NSIP Reference: TR050007

Natural England's comments in respect of the Hinckley National Rail Freight Interchange

Natural England's Relevant Representations

### ES FIGURE 14.4 - MAIN HNRFI SITE CONCEPT SURFACE WATER DRAINAGE STRATEGY

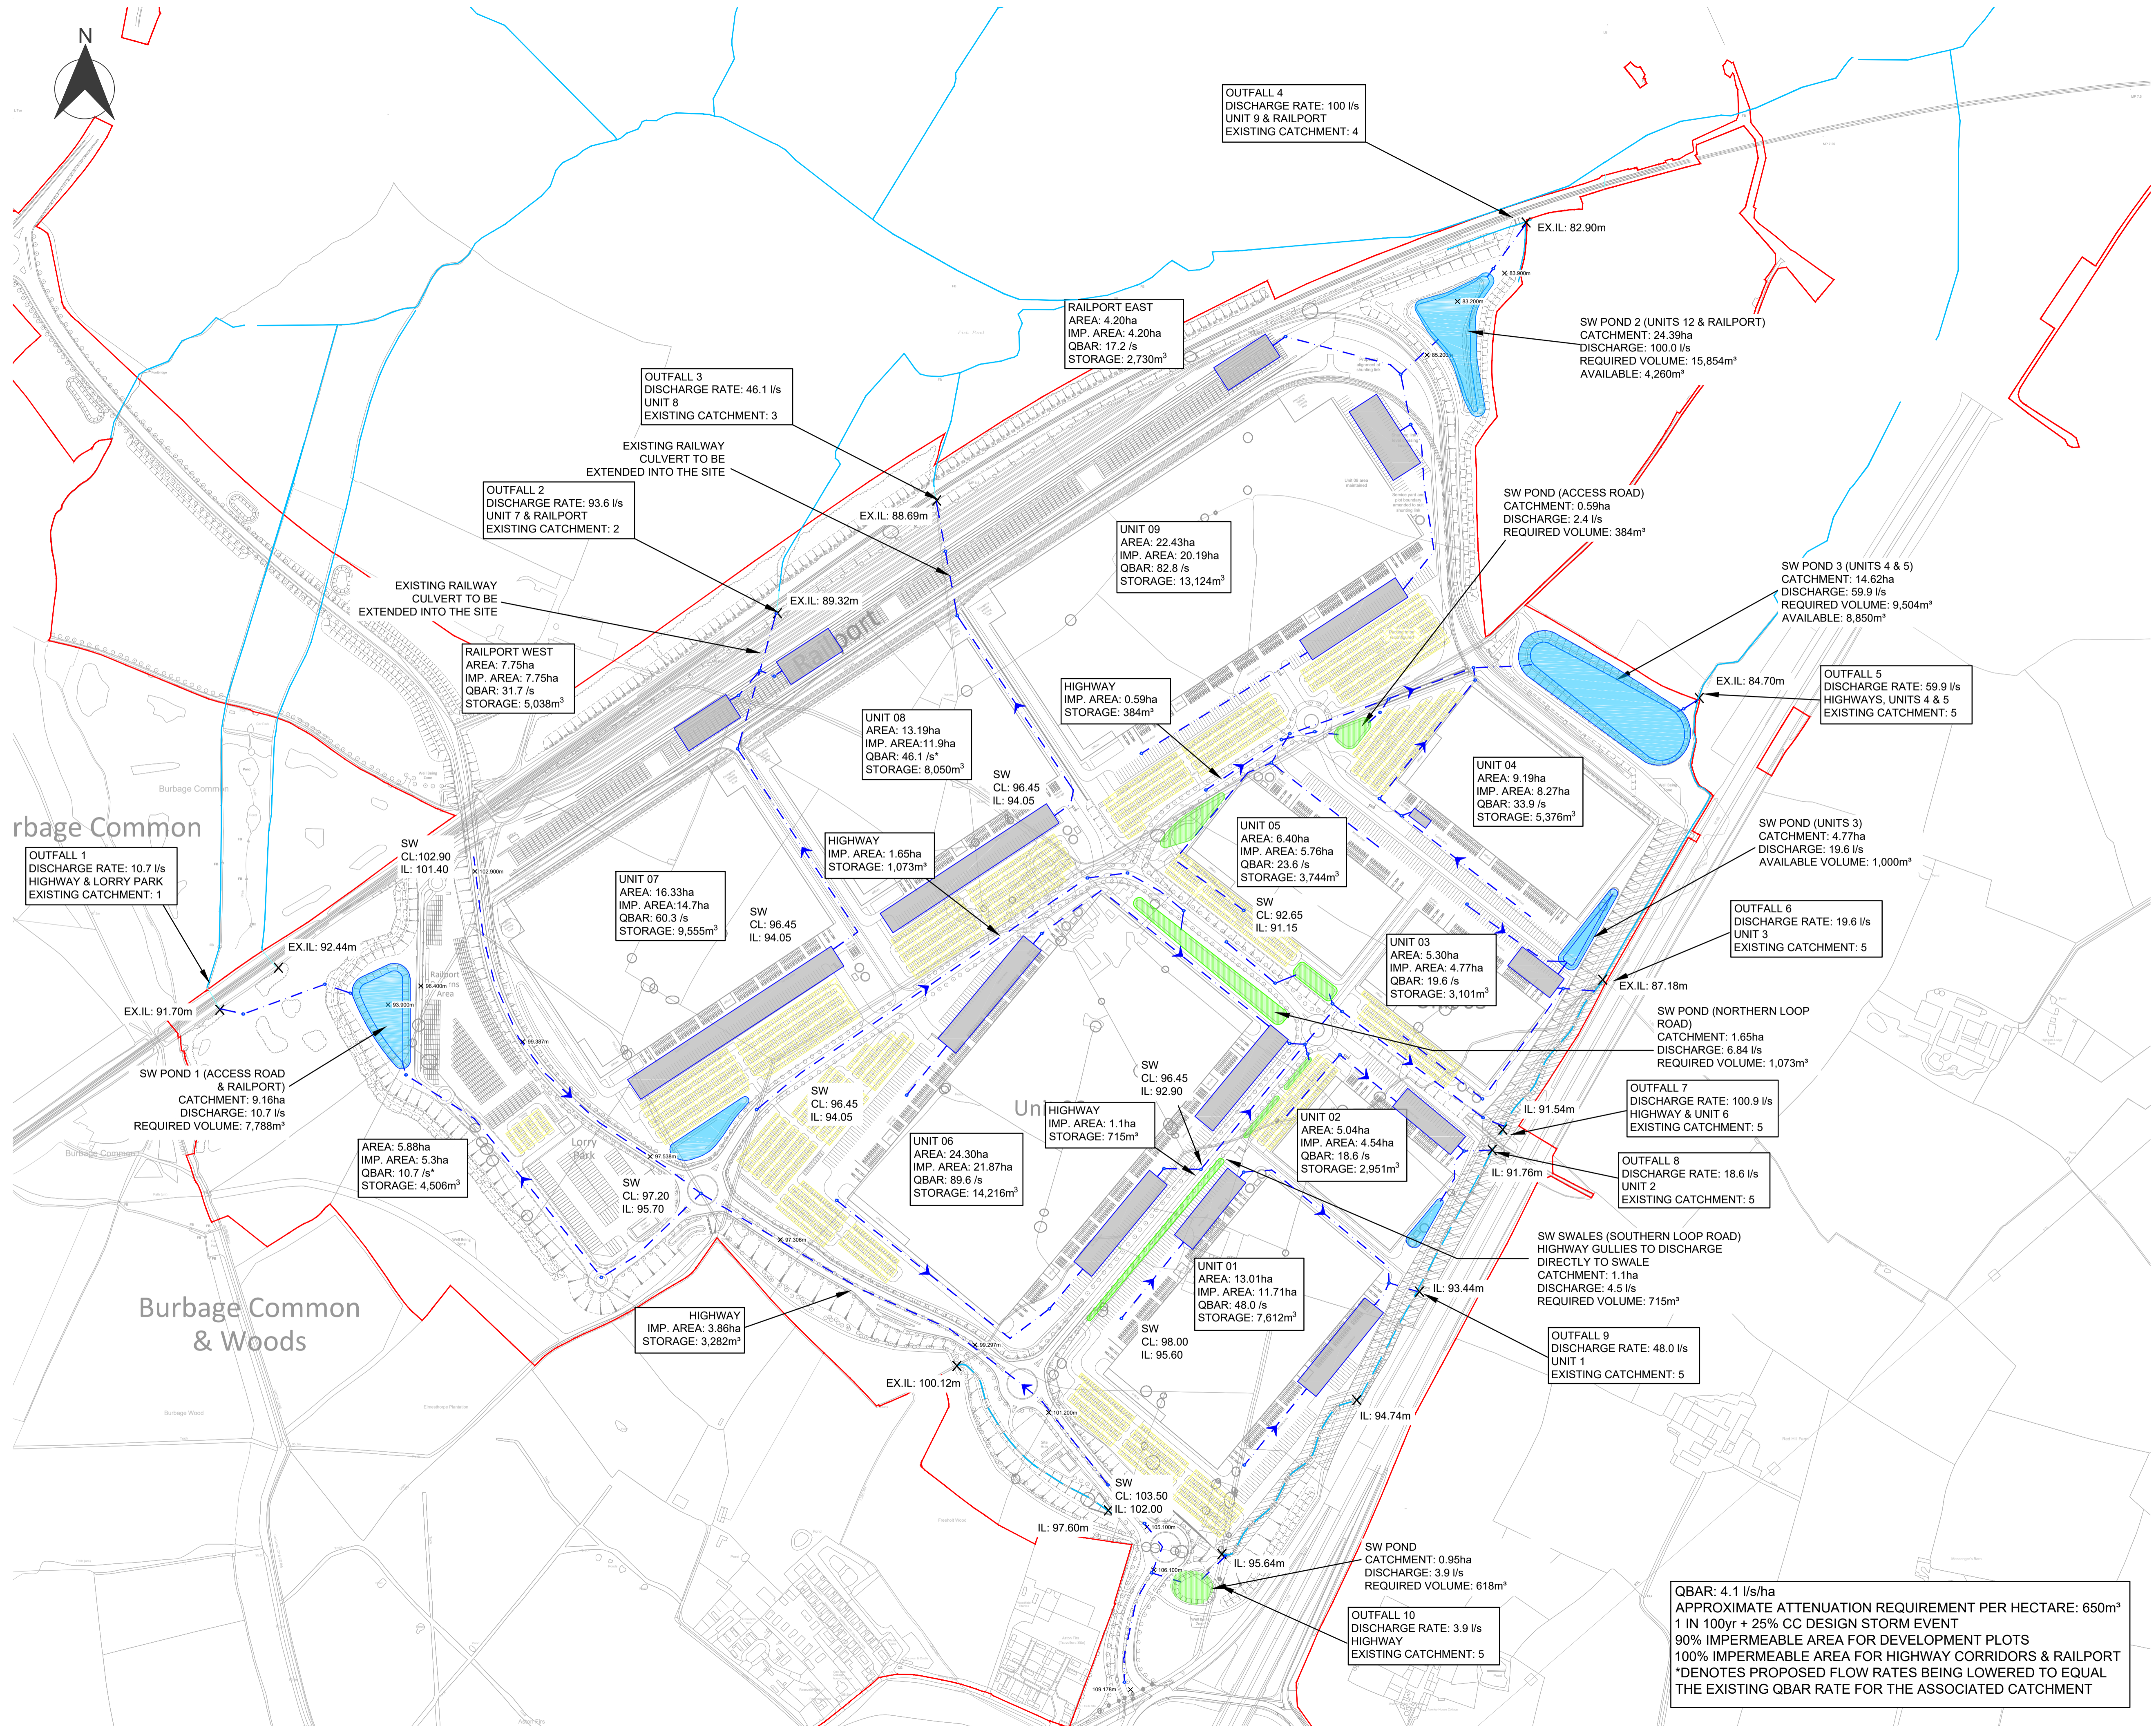
- As the proposed development site lies within the catchment of the SSSI, there is potential for oil spills and other pollutants from the operation of the site to enter the surface water environment and cause an adverse effect. Whilst the distance between the site and the SSSI is acknowledged, Natural England consider that a precautionary approach should be taken and measures put in place to prevent any pollutants from leaving the site.
- Appendix 14.2: Sustainable Drainage Statement sets out the proposals for surface water drainage from the proposed development; Natural England welcome the design of this drainage system being guided by CIRIA C753 The SuDS Manual. The surface water drainage scheme is

illustrated within Figure 14.4: Main HNRFI Site Concept Surface Water Drainage Strategy. The scheme includes the use of oil interceptors, swales, ponds and permeable paving. Natural England consider the drainage design to be suitable in preventing any likelihood of impacts to Narborough Bog during operation.
